5890  
GT

22 MAR 2012

**Planning Applications, Ribble Valley District  
3/11/1039 The Pentre, Pendle Road, Clitheroe**

Exisitn Site Plan

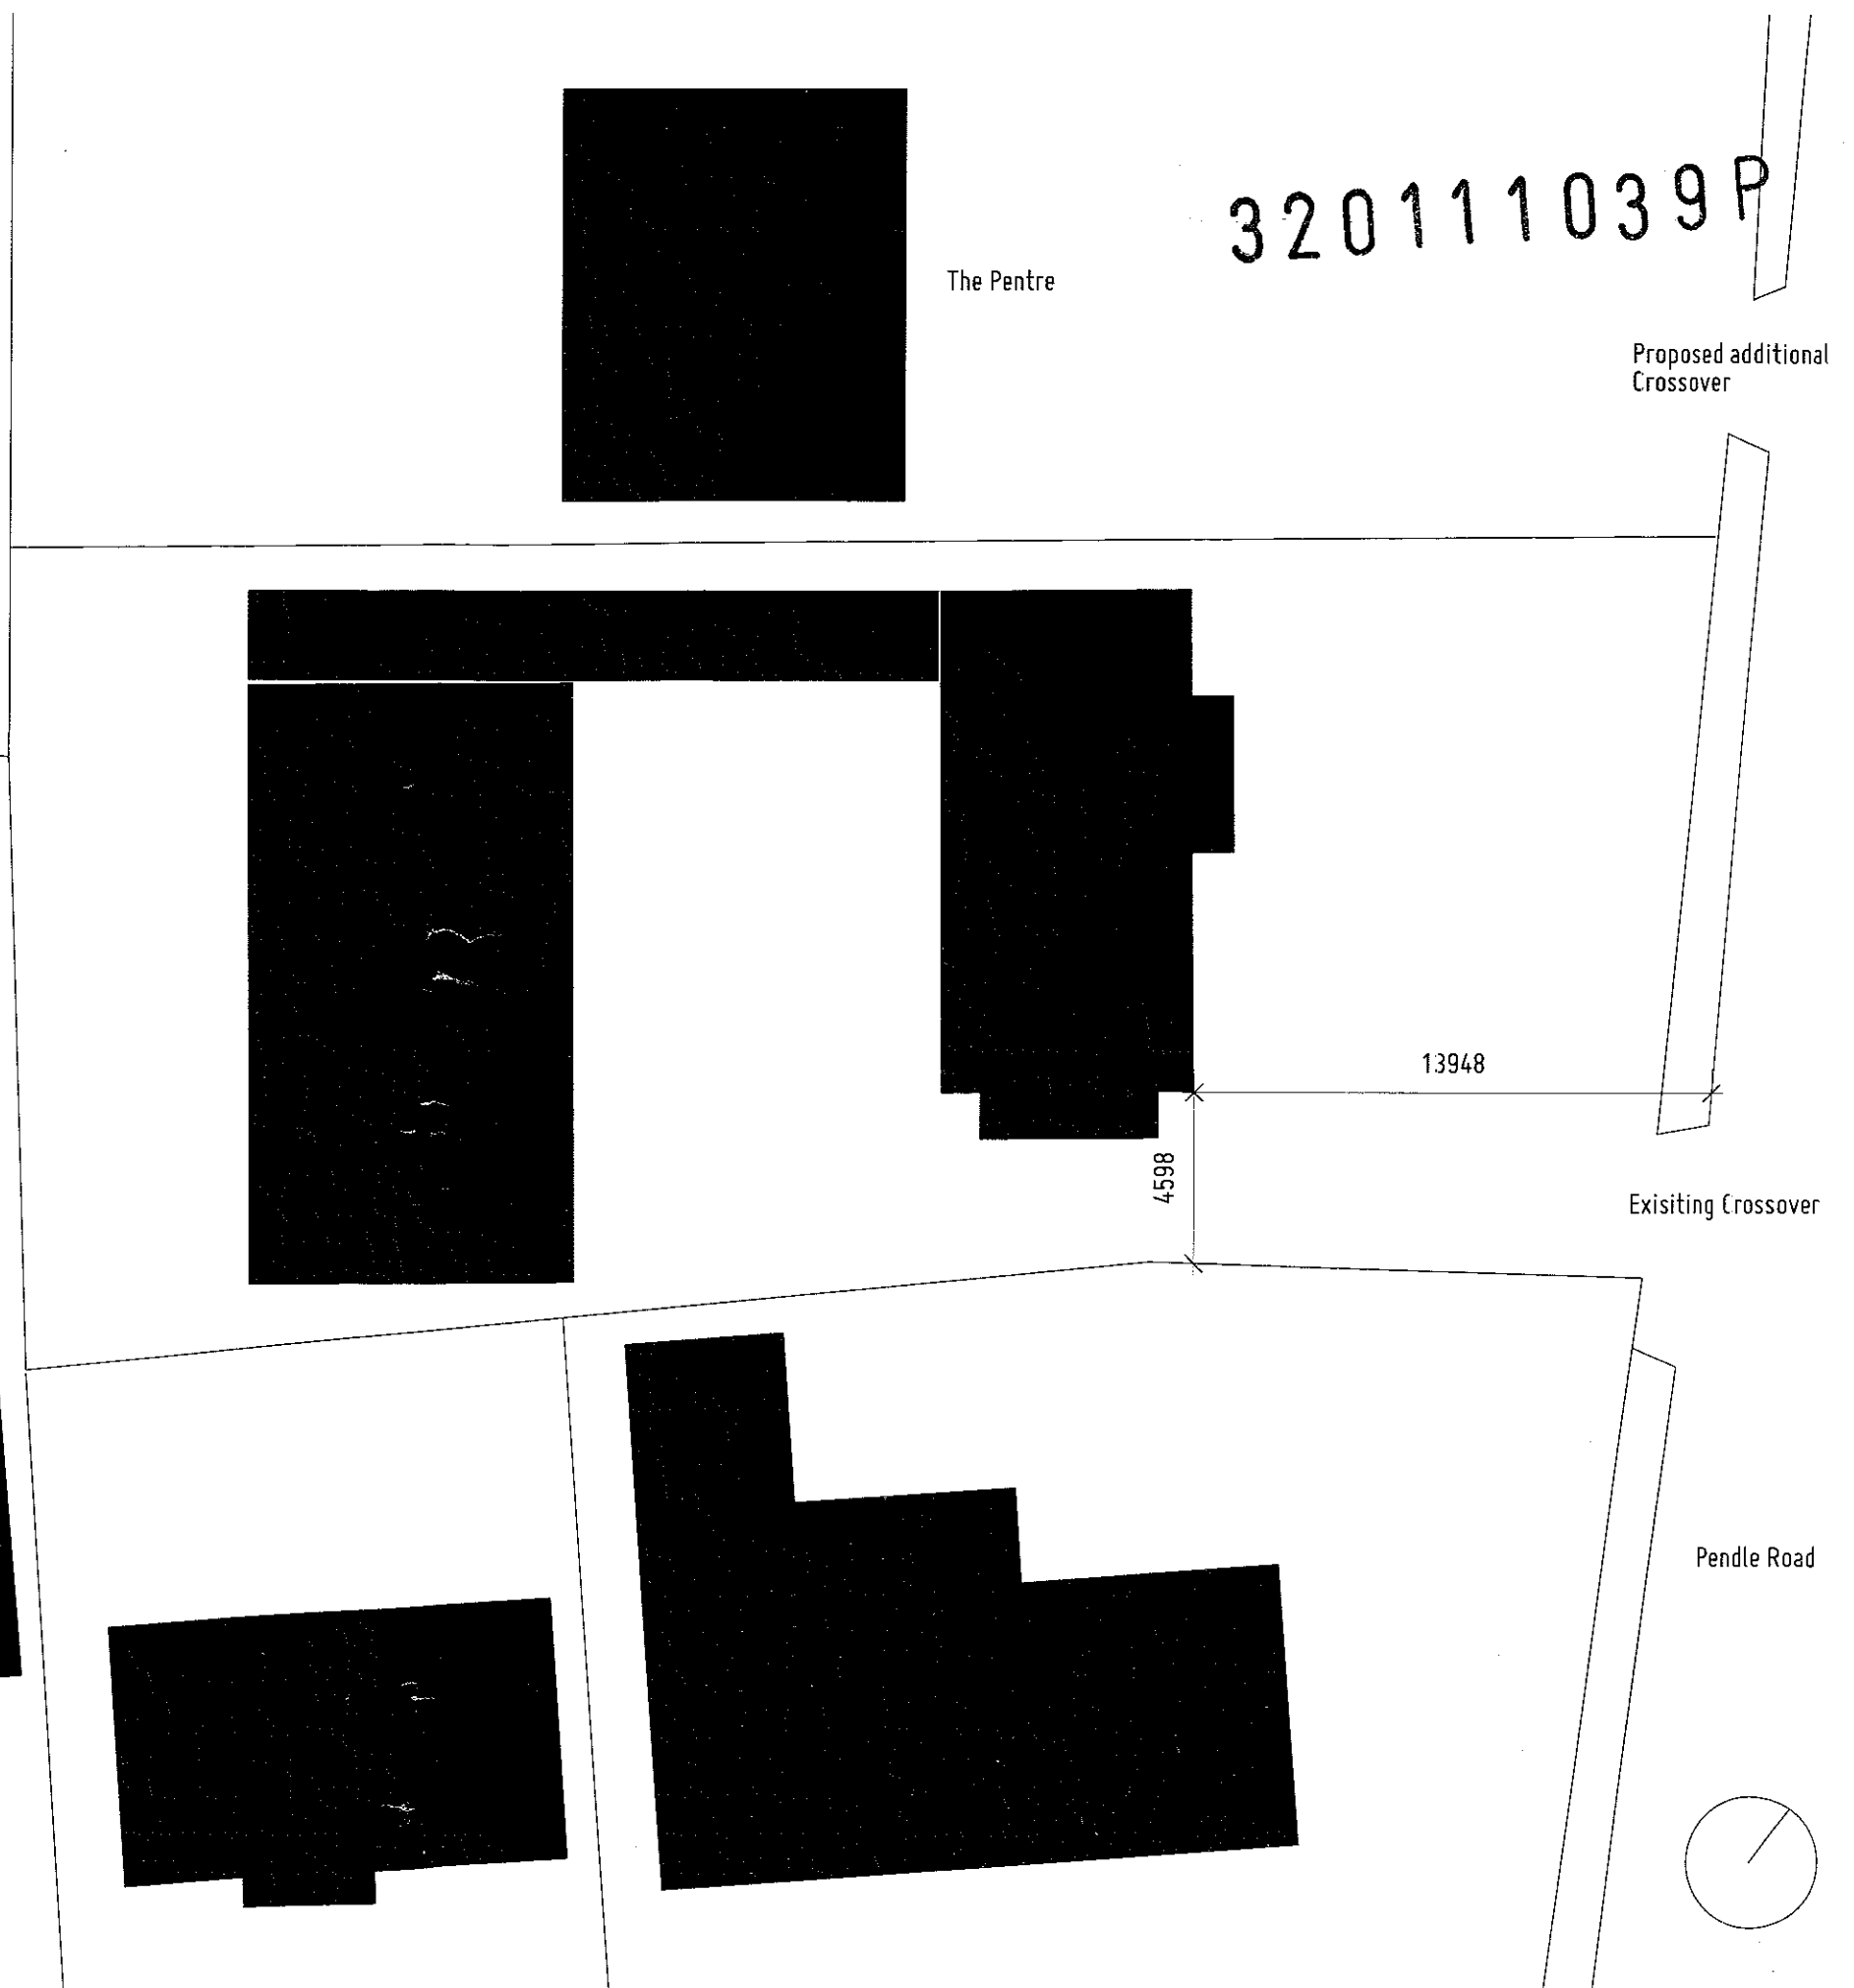
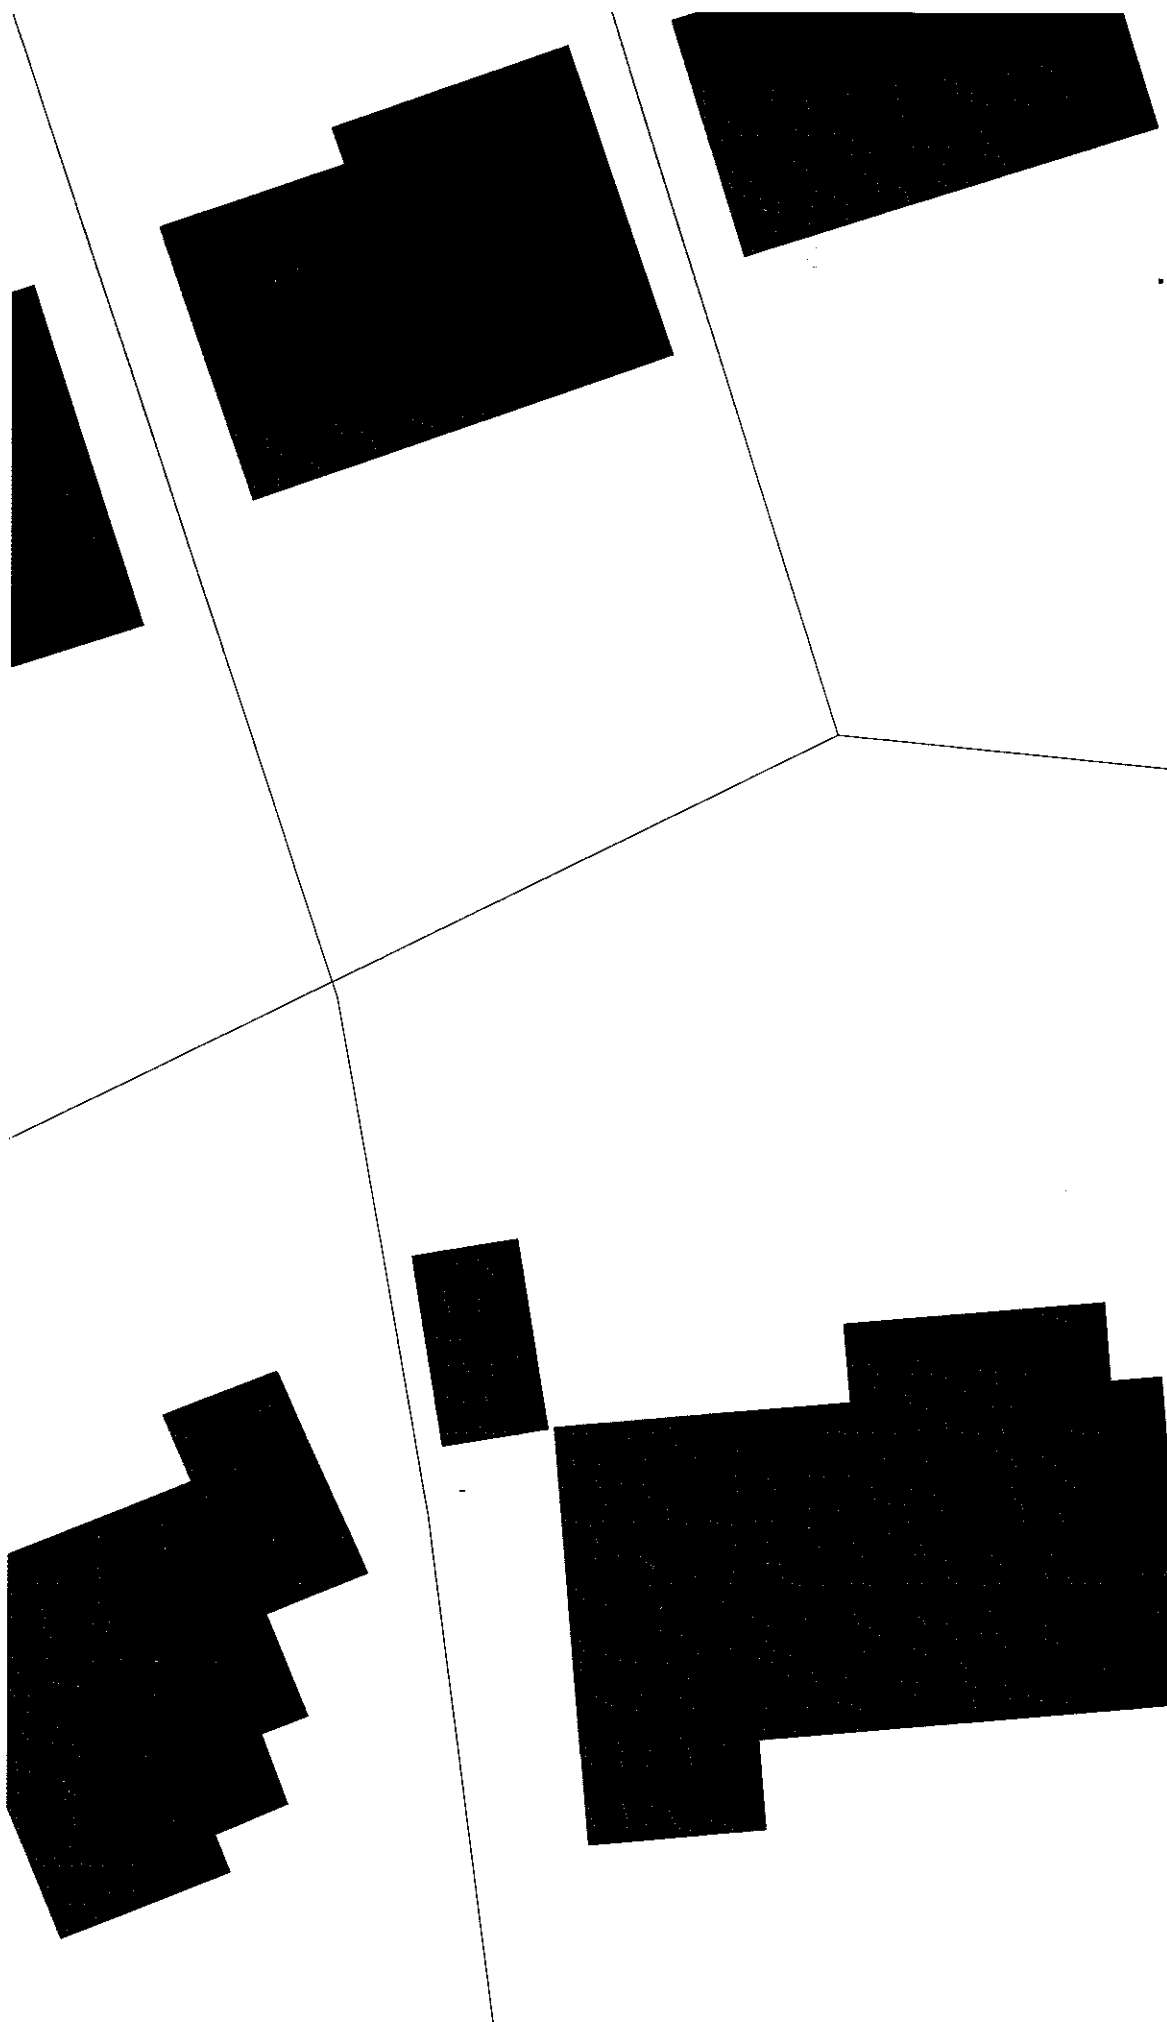
The creation of a new vehicular access will require the introduction of a drop kerb to Pendle Road and associated footway works. In addition, the possible relocation of a street lighting column (No 30) will have to be investigated as it falls within the splay of the new access. Both of these items will have to be completed at the applicant's expense and included in an appropriate Condition.

The new access must be designed to achieve a minimum visibility splay of 2.4m by 40m, with all planting and construction within this splay maintained at a maximum height of 0.9m.
